COMMUNITY SERVICES DEPARTMENT

September 7, 2022

Subject: Flying Horse North Sketch Plan, Review #2 (SKP-22-003)

FLYING HORSE NORTH SKETCH PLAN
SKETCH PLAN DRAWING

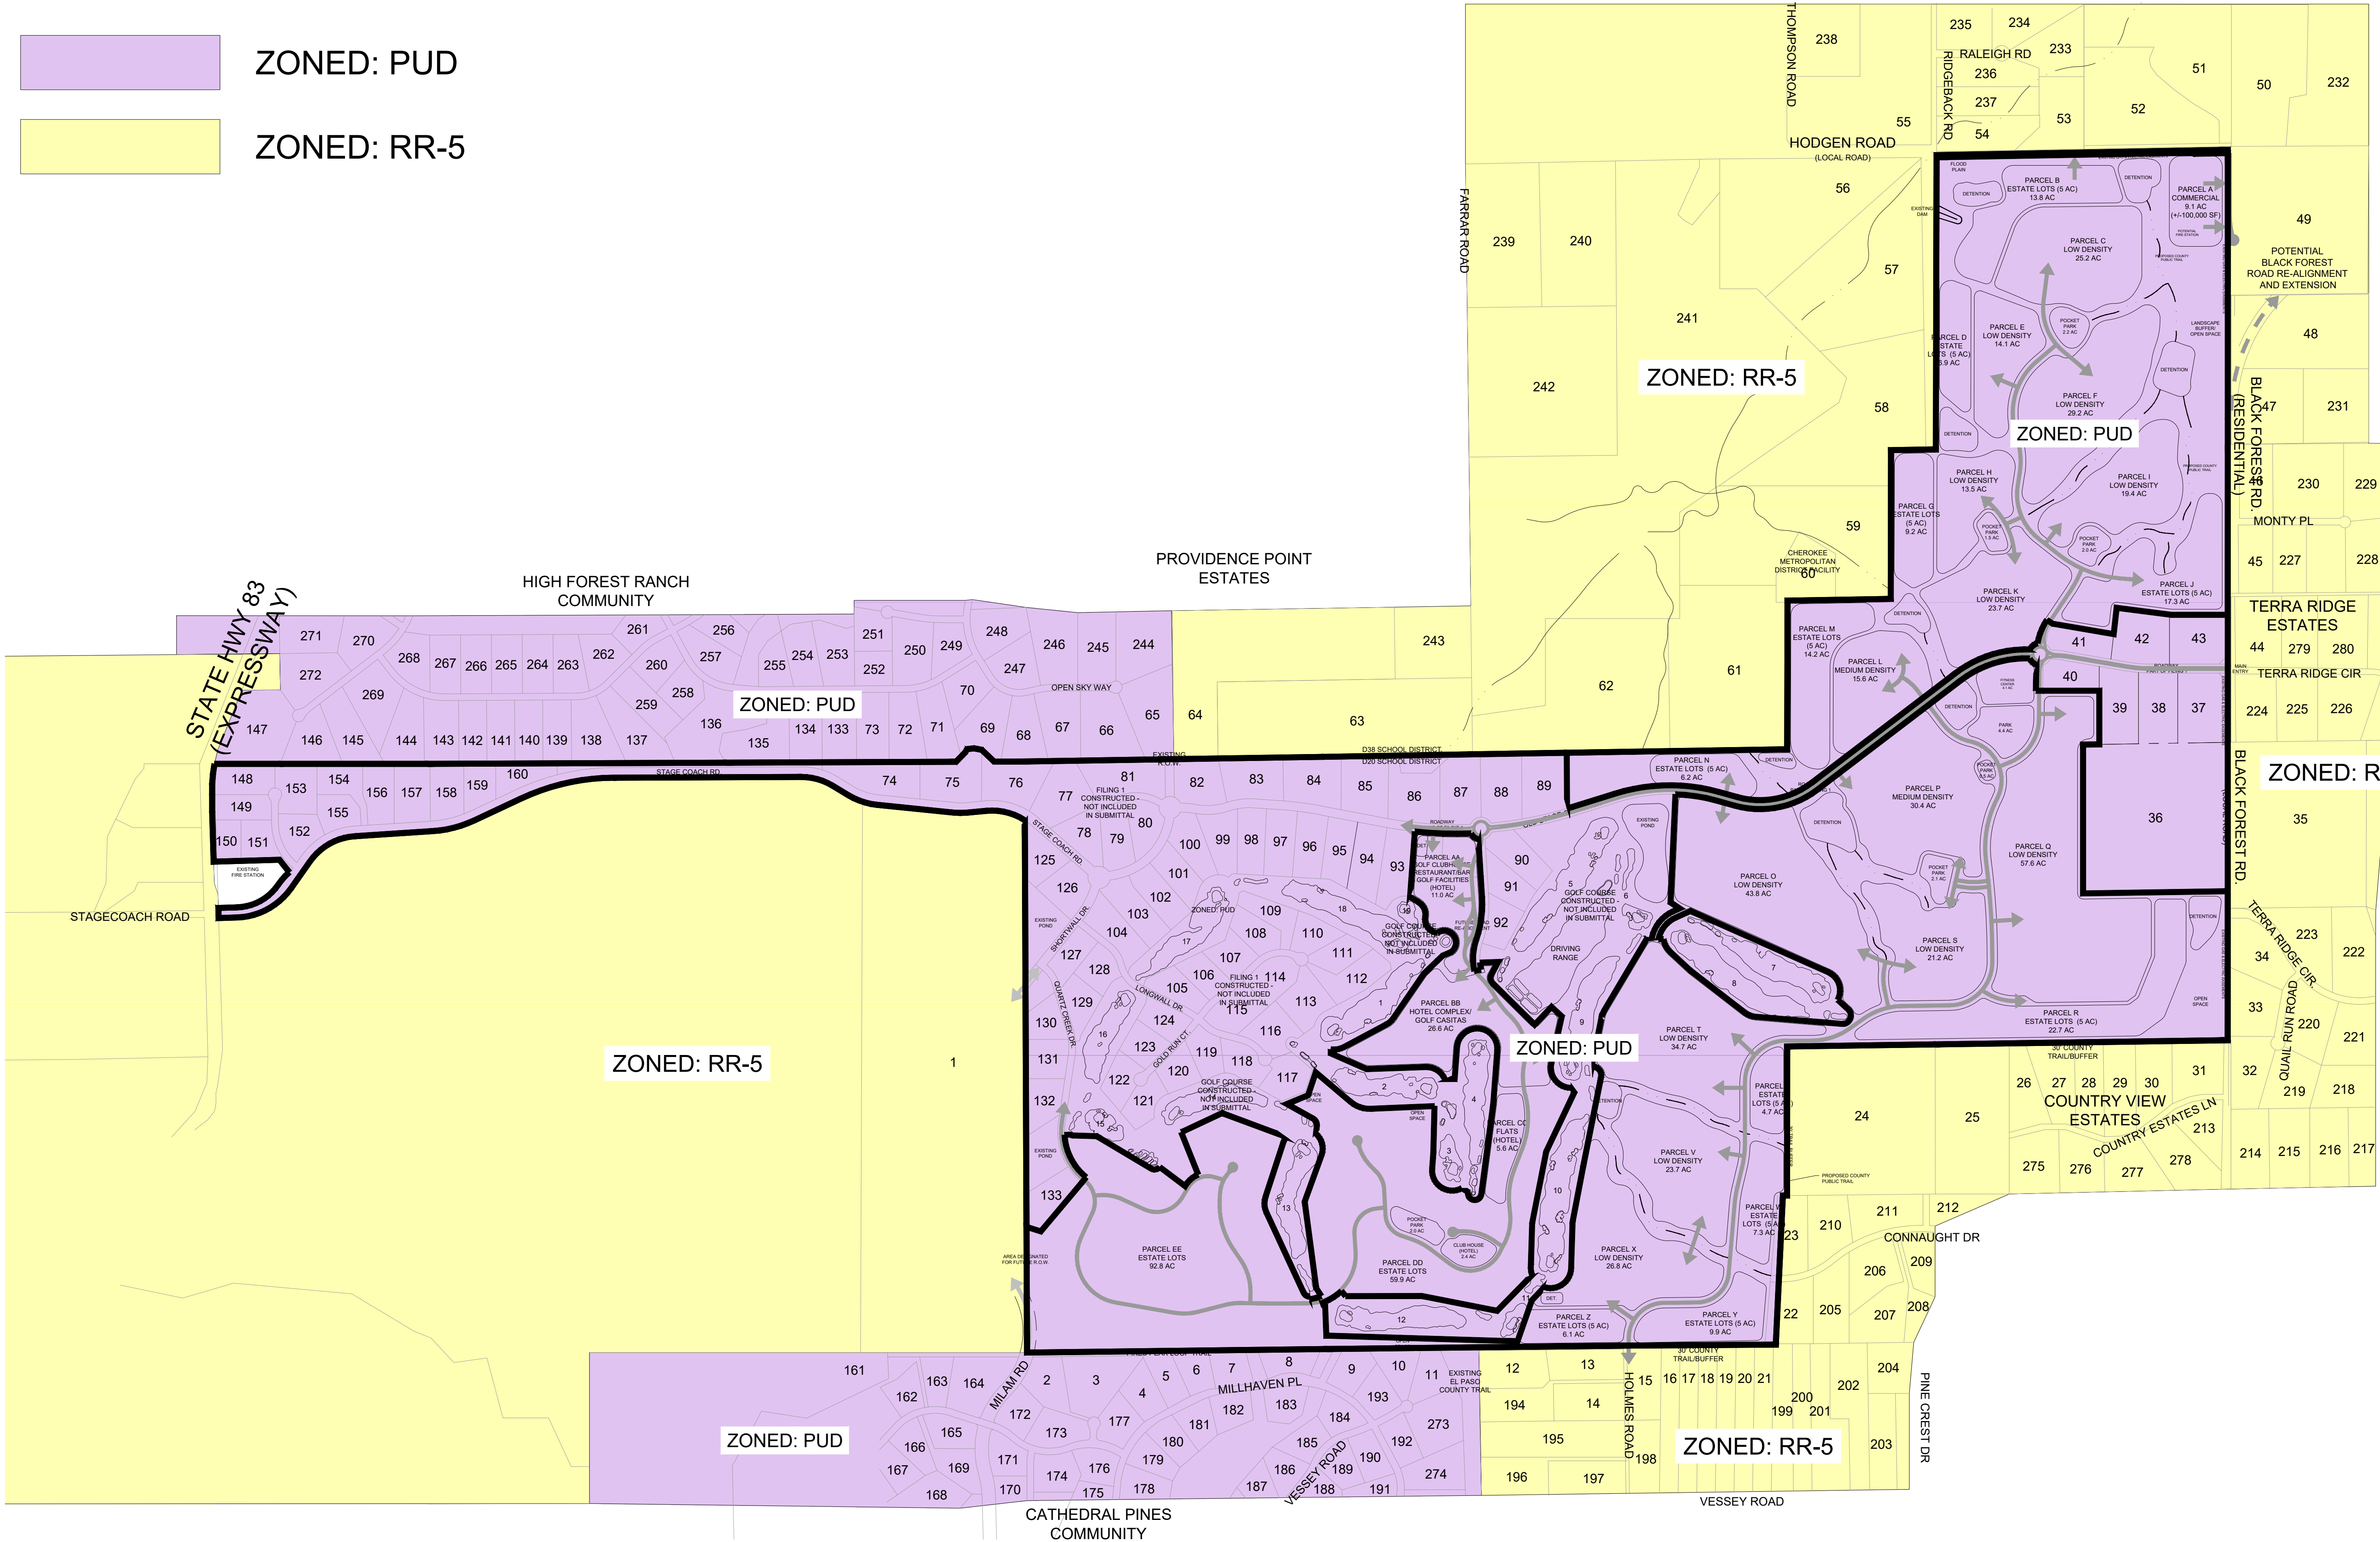
The original Flying Horse North Sketch Plan showed the regional trail alignment commencing at the northeastern corner of Black Forest Regional Park, running primarily north/south through interconnected open spaces, neighborhood parks, and drainages, where the trail connects to Hodgen Road at the project's northeast corner. In the current application, the trail has been relocated to the development's boundary. The Sketch Plan map included with this current submittal showed the Fox Run Trail leaving, then reentering the development along Black Forest Road, but this alignment was recently updated to keep the trail alignment within the bounds of the Flying Horse North development.

In early discussions, EPC Parks staff noted that the County trail would be designated as multi-use and allow for hiking, biking, and equestrian access. During the aforementioned virtual meeting between Parks staff and the applicant and applicant's representative, staff asked for an explanation for the relocation of the Fox Run Regional Trail from within the Flying Horse North Development to its outer landscape buffers. The reason was primarily centered on the multi-use aspect of the trail, specifically the use of the trails by equestrian users. While the applicant understands the need for the multi-use component of the regional trail, they feel that equestrian use would not be compatible with the overall character and nature of the community. Therefore, the regional trail was relocated to the perimeter of the subdivision.

While staff is pleased with the applicant's continuing efforts to provide a high level of recreational facilities and amenities to the residents and visitors of Flying Horse North, staff finds the realigned regional trail corridor less than adequate. This is primarily due to the confined nature of the trail, which restricts the trail designer's ability to work with the natural terrain features, thus resulting in a generally straight, non-sustainable trail. Staff recommends that the applicant design a corridor that allows for a more variable, interesting, and sustainable regional trail. Furthermore, staff recommends the applicant provide a 25-foot wide public regional trail easement to be dedicated to the County via forthcoming final plats for public access, construction, and maintenance of the primary regional trail.

The Park Advisory Board recommends that the Planning Commission and the Board of County Commissioners include the following conditions when considering and/or approving the Flying Horse North Sketch Plan: (1) designate and provide to El Paso County a 25-foot wide public regional trail easement that allows for public access, as well as construction and maintenance by El Paso County of the Fox Run Primary Regional Trail, and the easement be dedicated to the County via forthcoming final plat(s); and (2) fees in lieu of land dedication for regional park purposes in the amount of \$515,660 and urban park purposes in the amount of \$325,090 will be finalized at time of the submittal of the forthcoming preliminary plan(s) and required at time of the recording of the forthcoming final plat(s). Park Lands Agreements may be acceptable alternatives to regional and urban park fees, provided the agreements are submitted by the applicant, reviewed and approved by the County, and executed prior to recording the Final Plat(s).
